Medworth Energy from Waste Combined Heat and Power Facility

PINS ref. EN010110
Document Reference Vol.11.5
Revision: 1.0
Deadline: 3
April 2023

Applicant's comments on Deadline 2 submissions

Figure 8.1 Air quality survey monitoring locations , ES Chapter 8: Air Quality

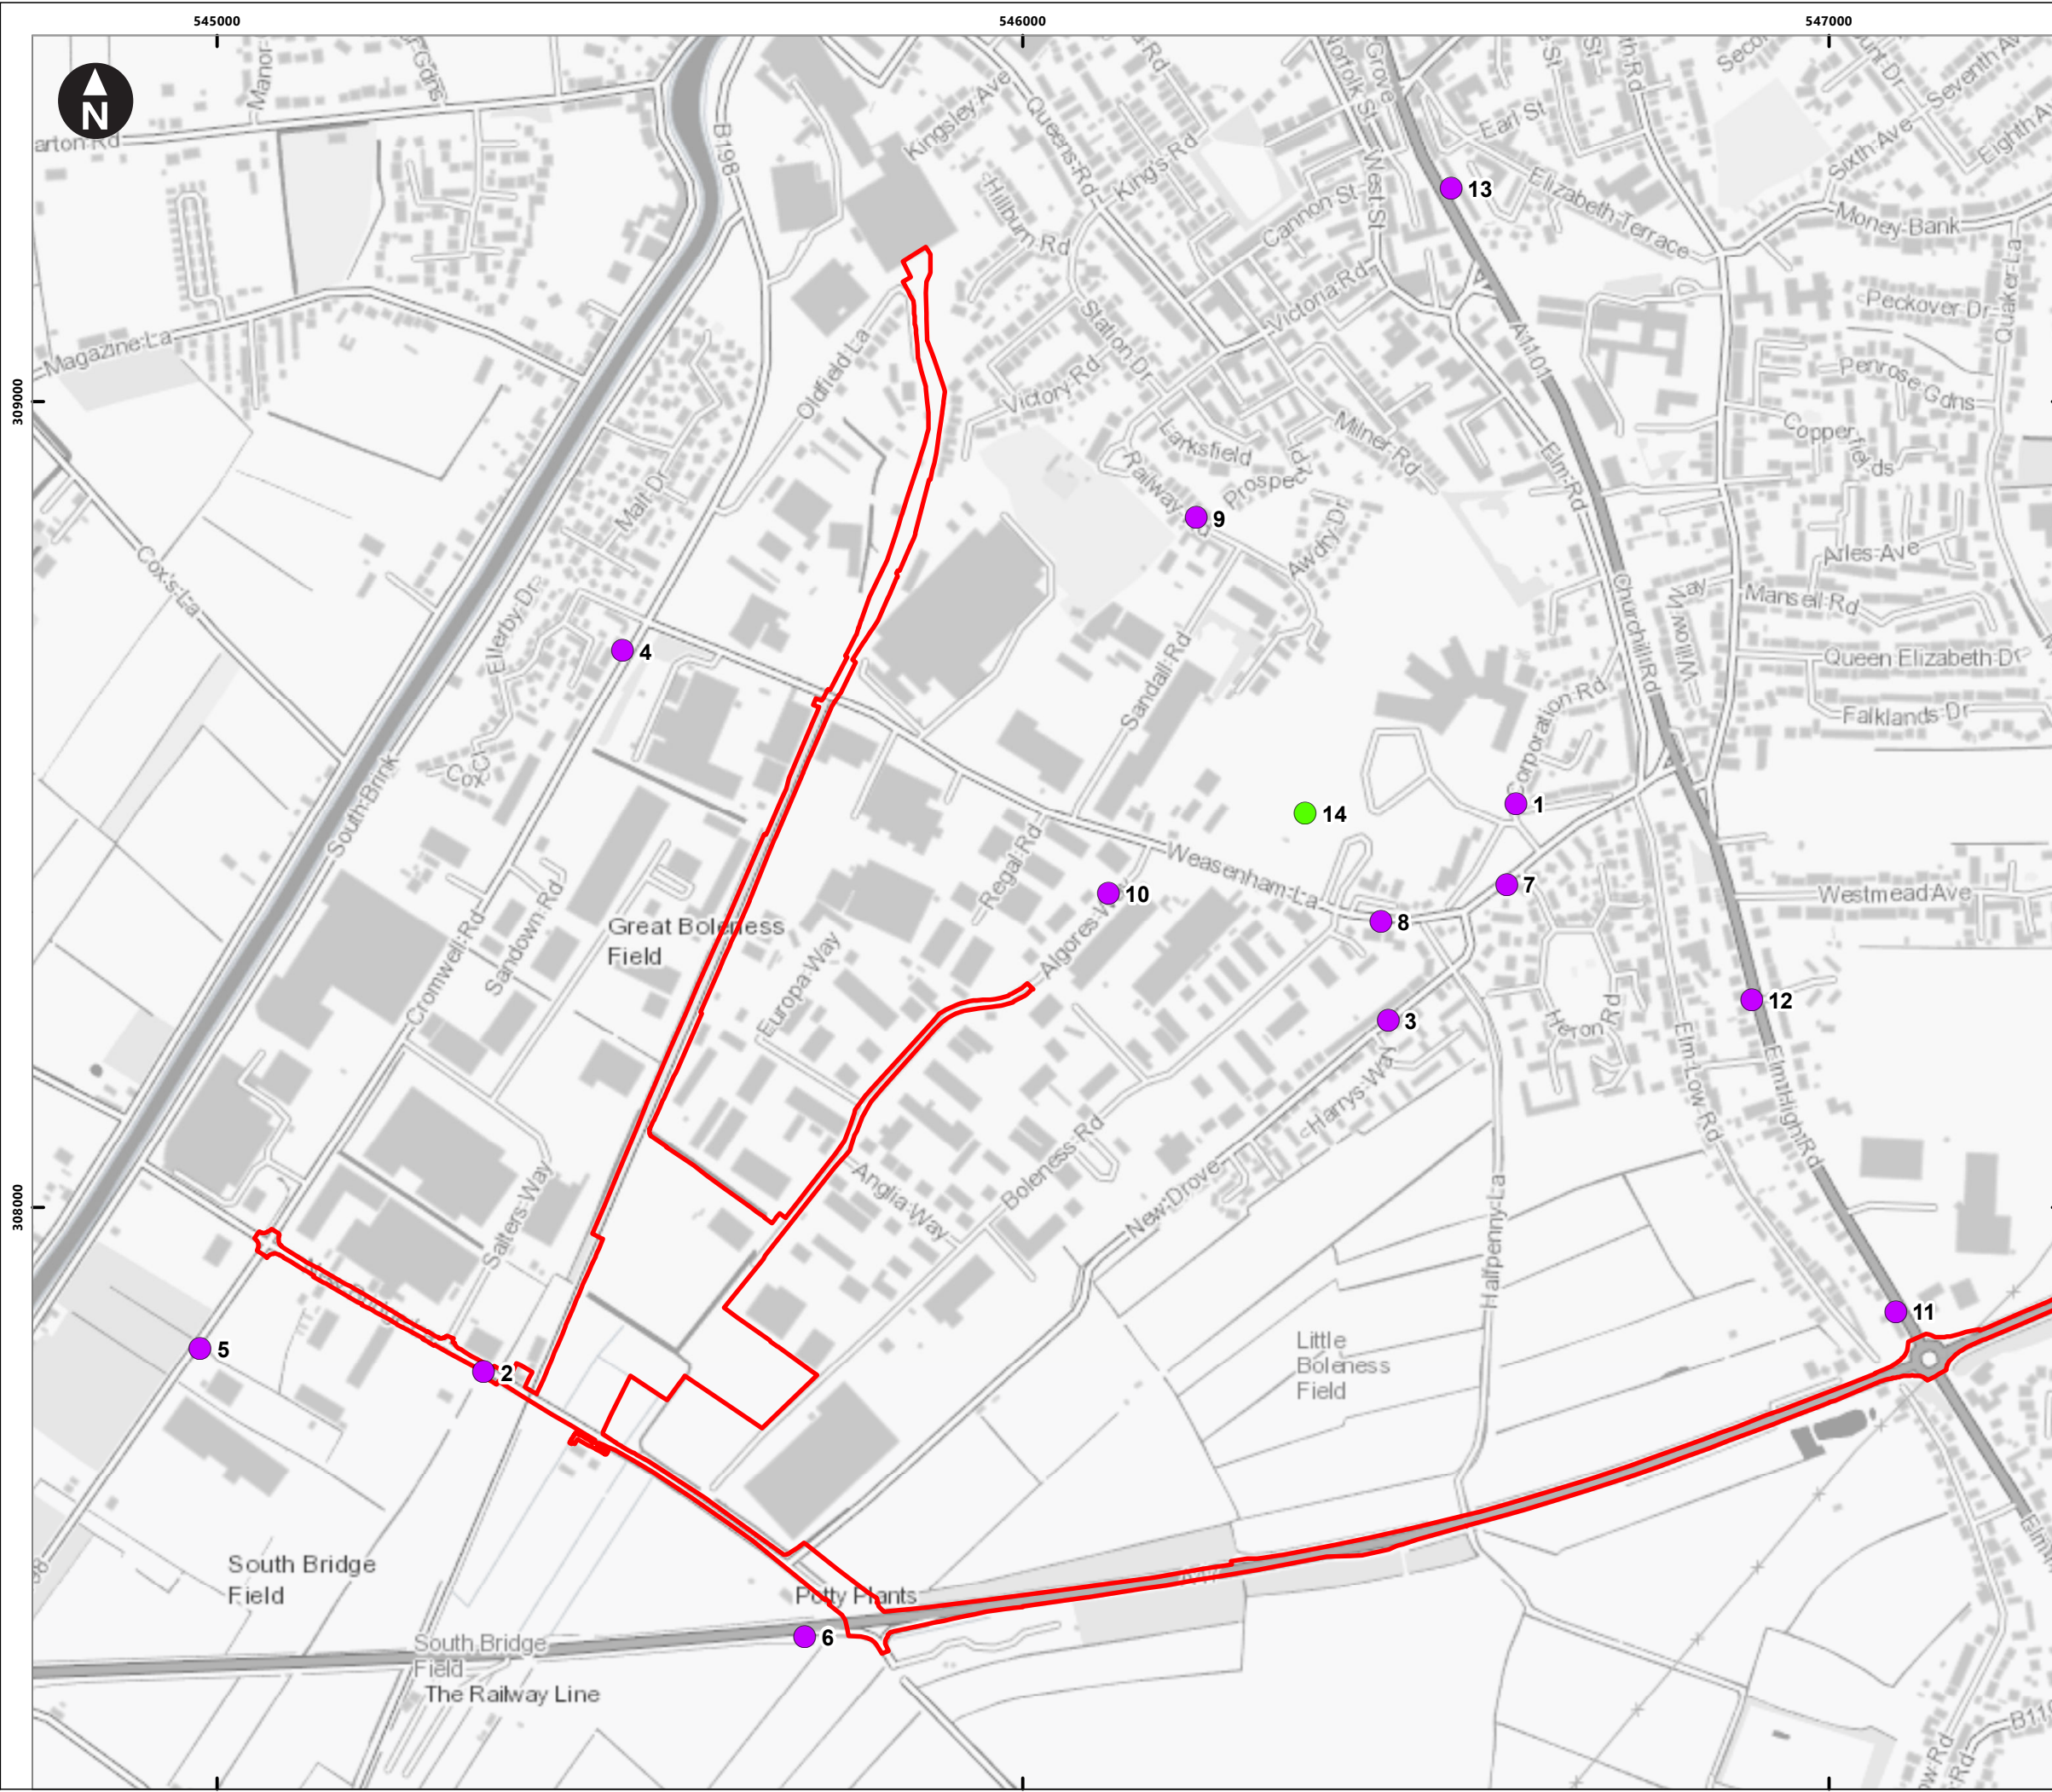
ID	Topic/Para	Response	Applicant Comment
CC56	9.21 Outline Local Air Quality Monitoring Strategy [REP1-055] Location of Diffusion Tube and Continuous monitoring General	This document includes the location of Diffusion Tube and Continuous monitoring for the operational period of the development. The Councils do not object to these locations, although seek to confirm them on completion of specific information regarding transport routes and equipment.	Submitted at Deadline 3, Section 2.4.1 to 2.4.2 of the Outline LAQMS (Volume 9.21) allows the locations for the monitoring equipment to be agreed as part of the final LAQMS.
CC57	9.21 Outline Local Air Quality Monitoring Strategy [REP1-055] Local Air Quality Management General	FDC would like to ensure that there is support for Local Air Quality Management, and request information is made available for the Annual Air Quality Screening Review and any Air Quality Action Planning if required.	Submitted at Deadline 3, Section 2.1.5 of the Outline LAQMS (Volume 9.21) was updated to accept written requests from the relevant planning authority. See the Applicant's response to KL05, above.

Table 3.1 Nearest sensitive Receptors

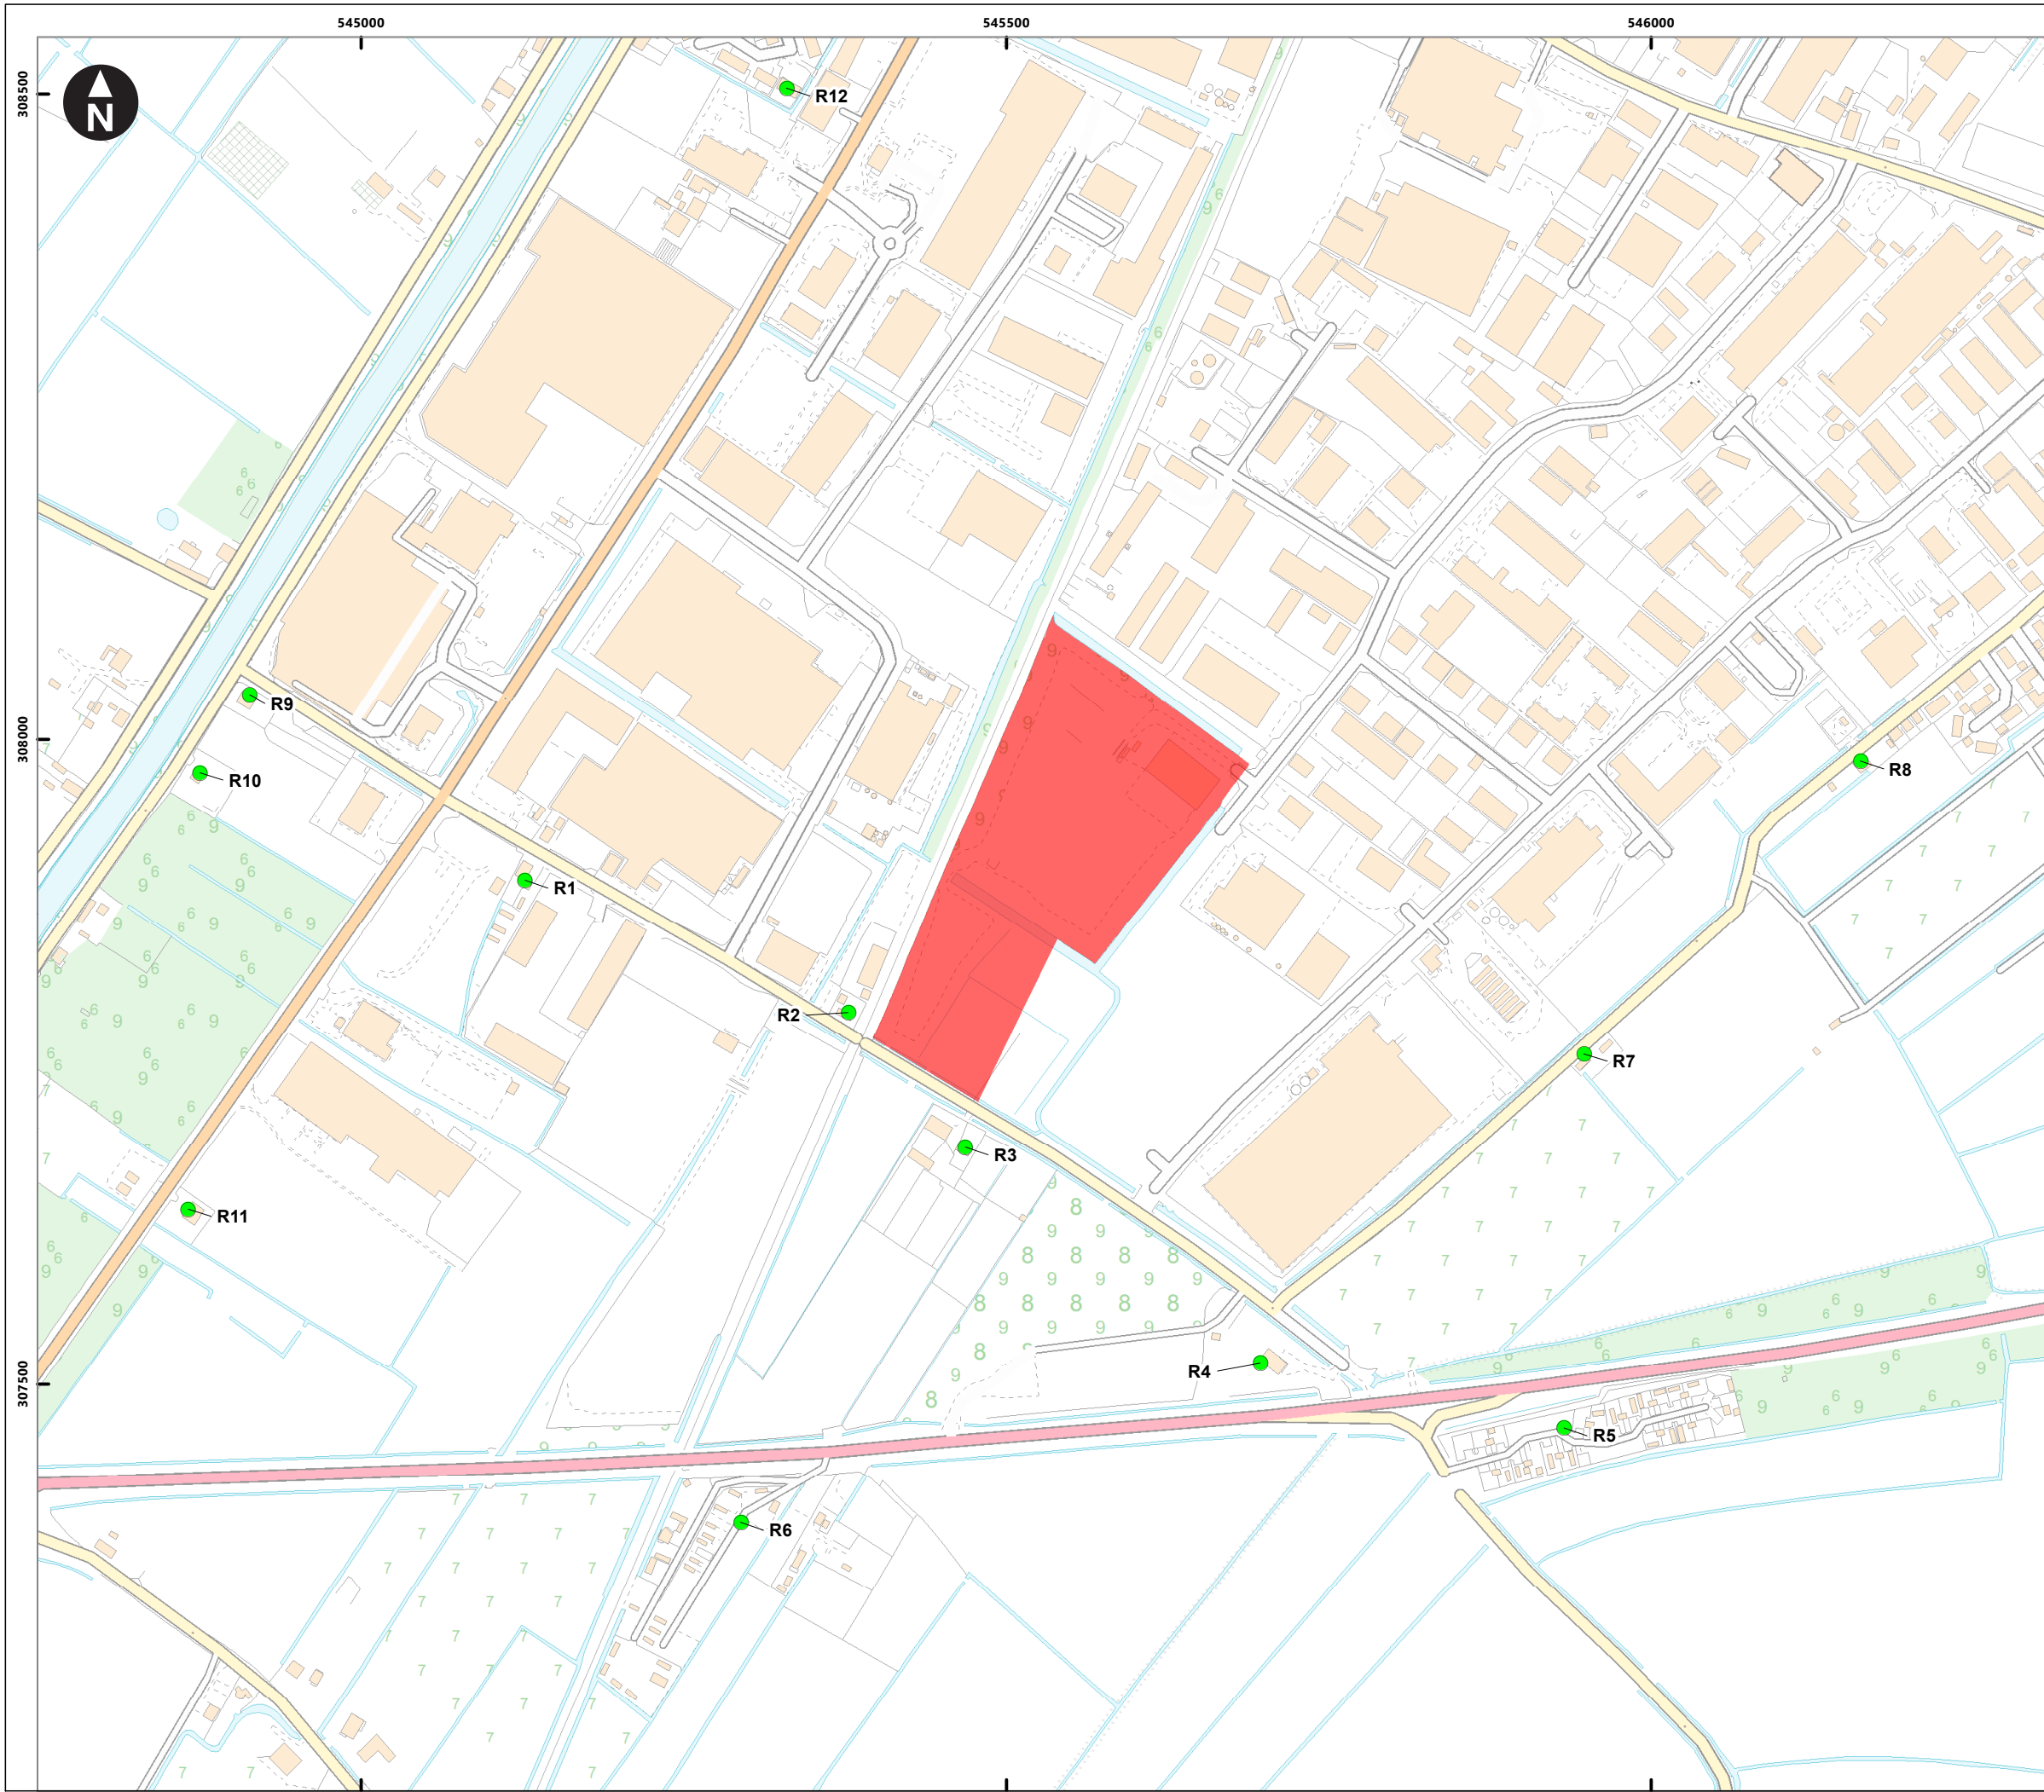
CC11	6.4 Environmental Statement - Chapter 7 - Noise and Vibration Appendix 7D - Outline Operational	The Councils would like to highlight that predicted operational noise effects from the permitted installation has excluded R2. Although it is understood that it is the intention for this development to purchase the property, and therefore it will no longer be a receptor. Until a time when this property is no longer a residential property, R2 is still a valid receptor and should be included in the table.	<p>On the 24 August 2022, the Applicant informed the ExA it had acquired R2 (9 New Bridge Lane) and consequently updated the Book of Reference (Volume 4.1) [AS-006].</p> <p>Since acquiring the property, the Applicant confirms it is and shall remain unoccupied.</p>

ID	Topic/Para	Response	Applicant Comment
	Noise Management Plan (Tracked) - Rev 2 [REP1-012]		Draft DCO Requirement 19 (Noise Management) (Volume 3.1) [REP1-007] secures the cessation of use of R2 (9 New Bridge Lane) as a residential property.
	Exclusion of R2		
	Table 4.1		
CC12	6.4 Environmental Statement - Chapter 7 - Noise and Vibration Appendix 7D - Outline Operational Noise Management Plan (Tracked) - Rev 2 [REP1-012]	In addition to the location of an acoustic fence at 10 New Bridge Lane, the design features of any acoustic fence including should be detailed in the report including its height, materials of construction and noise attenuation calculations. It should be demonstrated that the fence will be sufficient to achieve the outcome specified in Table 4.1 after mitigation. If the owners or occupiers of 10 New Bridge Lane are not agreeable to this mitigation measure, an alternative option(s) should be provided.	<p>The Applicant confirms that during the production of the Outline Noise Management Plan Appendix 7D (Volume 6.4) [REP1-012], the Applicant has engaged in discussions with the owners of 10 New Bridge Lane to confirm their requirements regarding materials and width of entrance to their property. The Outline Operational Noise Management Plan, Appendix 7D (Volume 6.4) [REP1-012] was updated to include reference to agreeing the detailed design with the owners of 10 New Bridge Lane.</p> <p>The detailed design, including the acoustic properties of the fence, will be submitted to the relevant planning authority for approval. The detailed information will demonstrate that the fence will be sufficient to achieve the outcome specified in Table 4.1 (Appendix 7D (Volume 6.4) [REP1-012]) after mitigation.</p> <p>The detailed design is secured by the Operational Noise Management Plan; a Draft DCO Requirement 19 (Noise Management) (Volume 3.1) [REP1-007].</p>
